RE: State Significant Development Application SSD-75493483 at 2-32 Junction Street, Forest Lodge (Forest Lodge Integrated Seniors Living)

- **Sydney Water objects to SSD-75493483 in its current form.**
- A 1524x1371 Sydney Water stormwater channel traverses the western boundary of the development site.
- As per Sydney Water's Specialist Engineering Assessment Procedure, driveways over our stormwater channels must be at-grade. The plans provided to Sydney Water indicate that the Larkin Street driveway will be elevated, which is not permitted.
- Furthermore, it is unclear from the plans presented whether Building A meets Sydney Water's requirement for no permanent structures to be constructed within 1.5 metres of the outside face of a stormwater channel.

SECTION 05 - DRIVEWAY

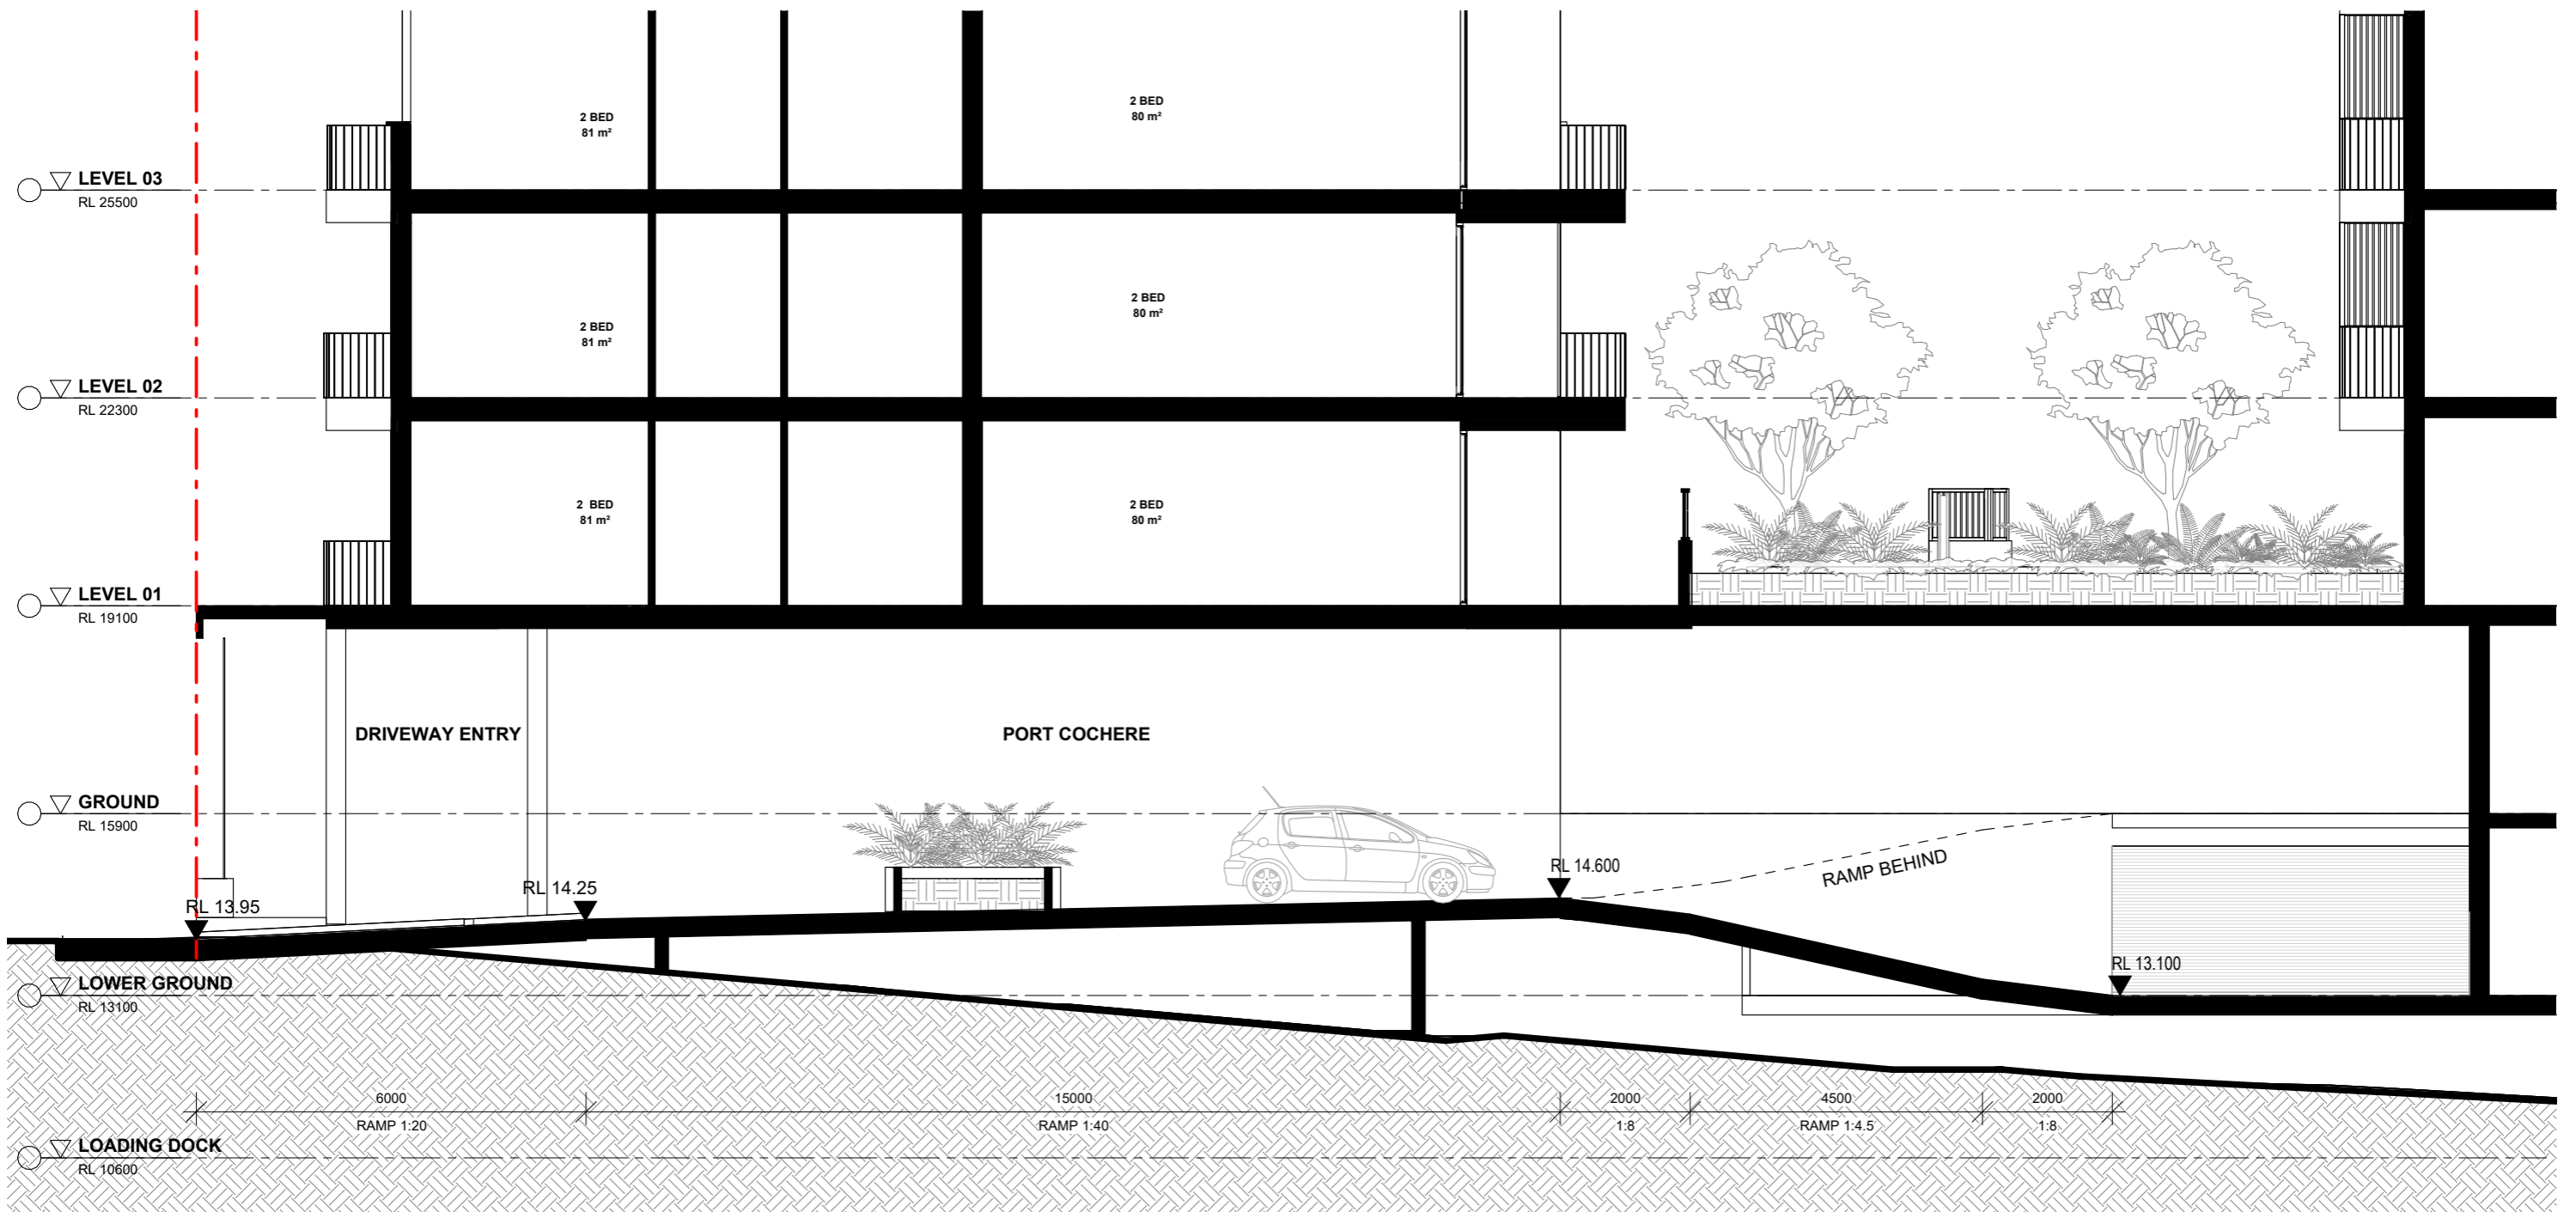
- The proponent is advised to revise their plans to ensure that:
 - The Larkin Street driveway meets Sydney Water's current Specialist Engineering Assessment Procedure ([Specialist engineering assessment procedure D0001870](#)) by crossing the stormwater channel at-grade, and remaining at-grade for 1.5 metres directly adjacent to the stormwater channel.

TITLE
SITWORKS AND DRAINAGE PLAN
GROUND FLOOR

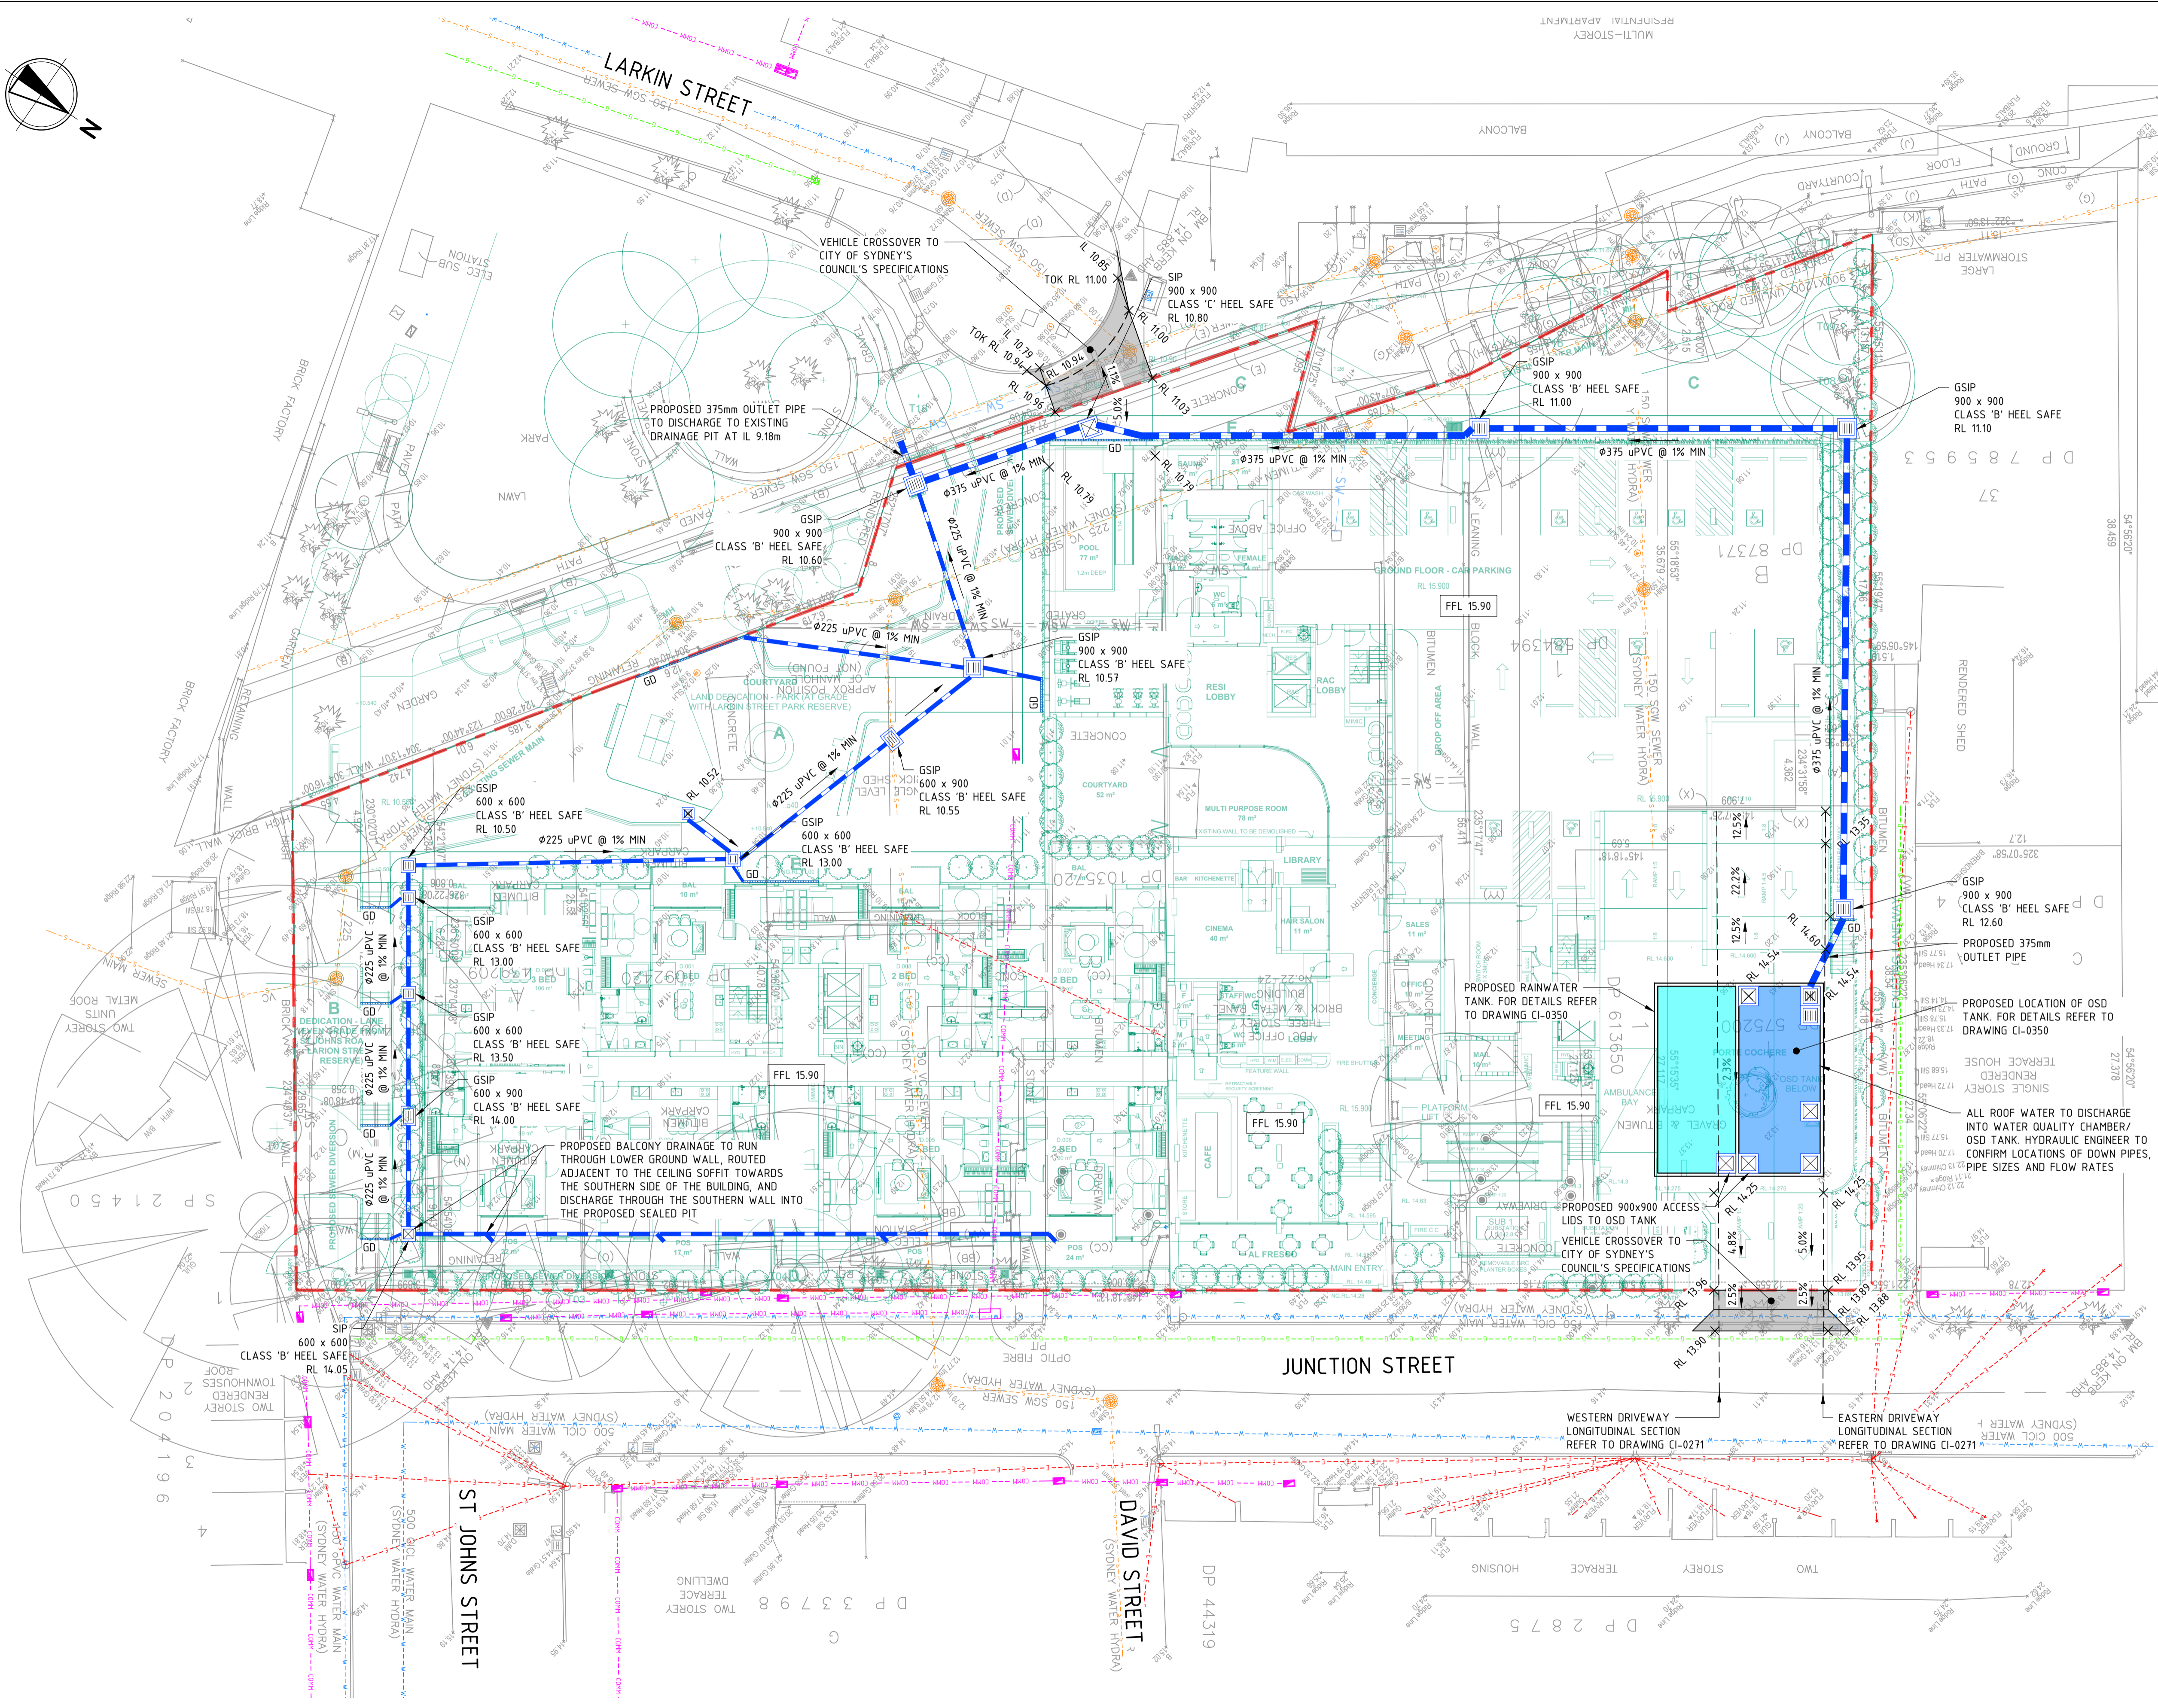
- The plans indicate clearly that Building A maintains 1.5 metres of clearance from the stormwater channel aforementioned.
- DPHI is advised to forward the enclosed Sydney Water Development Application Information Sheet (for proponent) to assist the proponent in progressing their development. This Info Sheet contains details on how to make further applications to Sydney Water and provides more information on Infrastructure Contributions.
